**Waterloo Metro Quarter OSD - Central Precinct Detailed Design SSDA (SSD-10439)  
Request for additional information**

I refer to Assessment for the Waterloo Metro Quarter OSD - Central Precinct Detailed Design SSDA (SSD-10439). We require additional information noted below to progress the assessment:

Floor Plan - Level 3-19

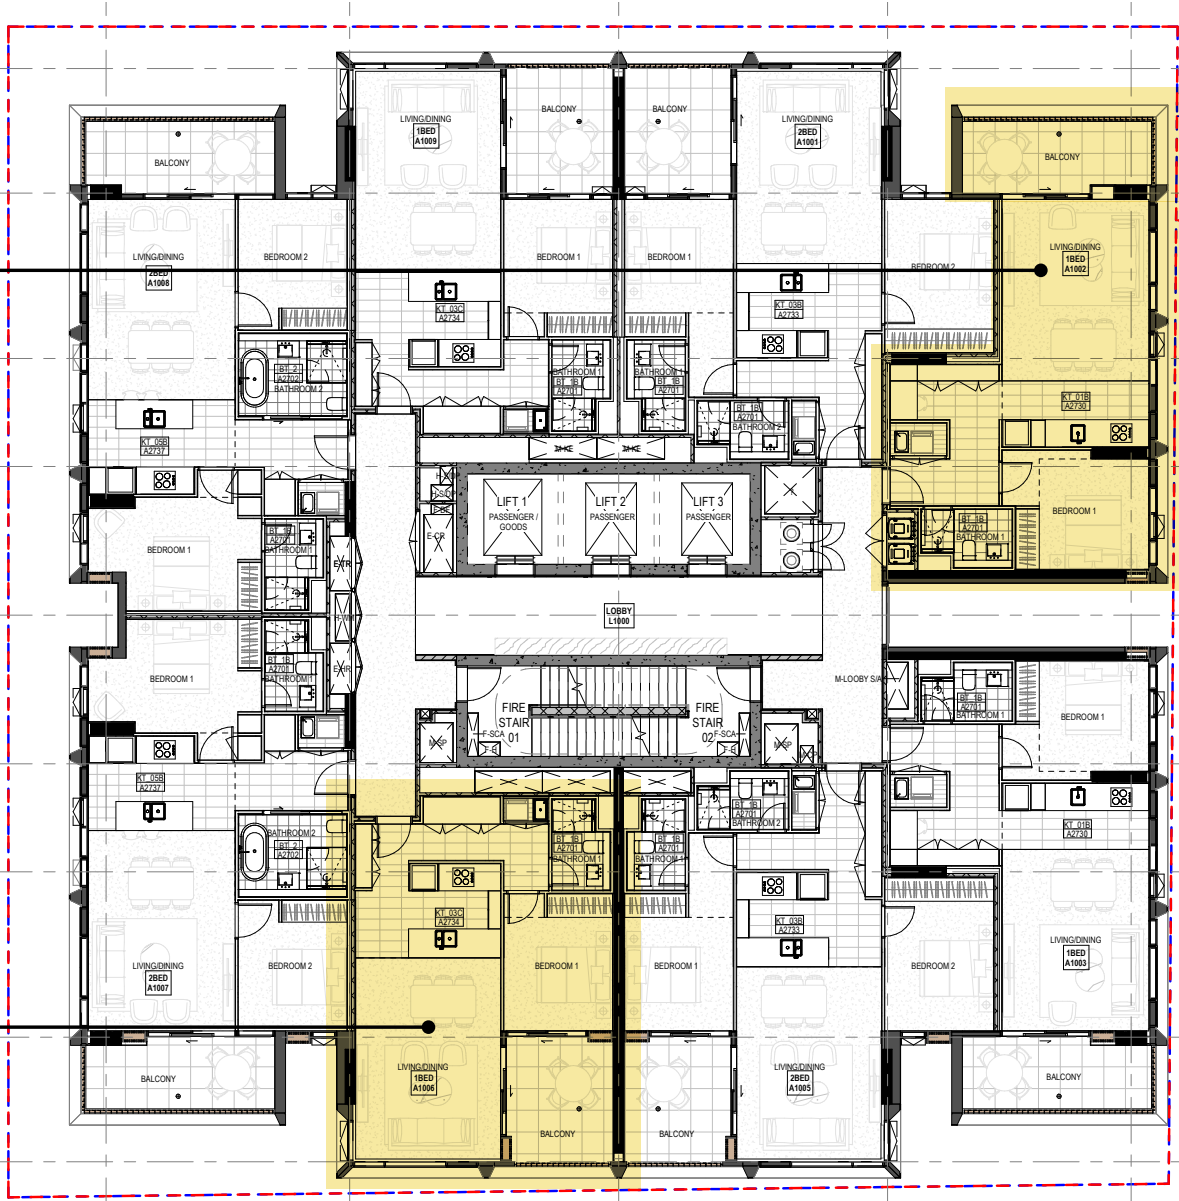
- consider design options to maximise solar access to apartment living rooms and private open space. This should include consideration of changes to layout of apartments and increasing the number of apartments with a northern or eastern aspect.
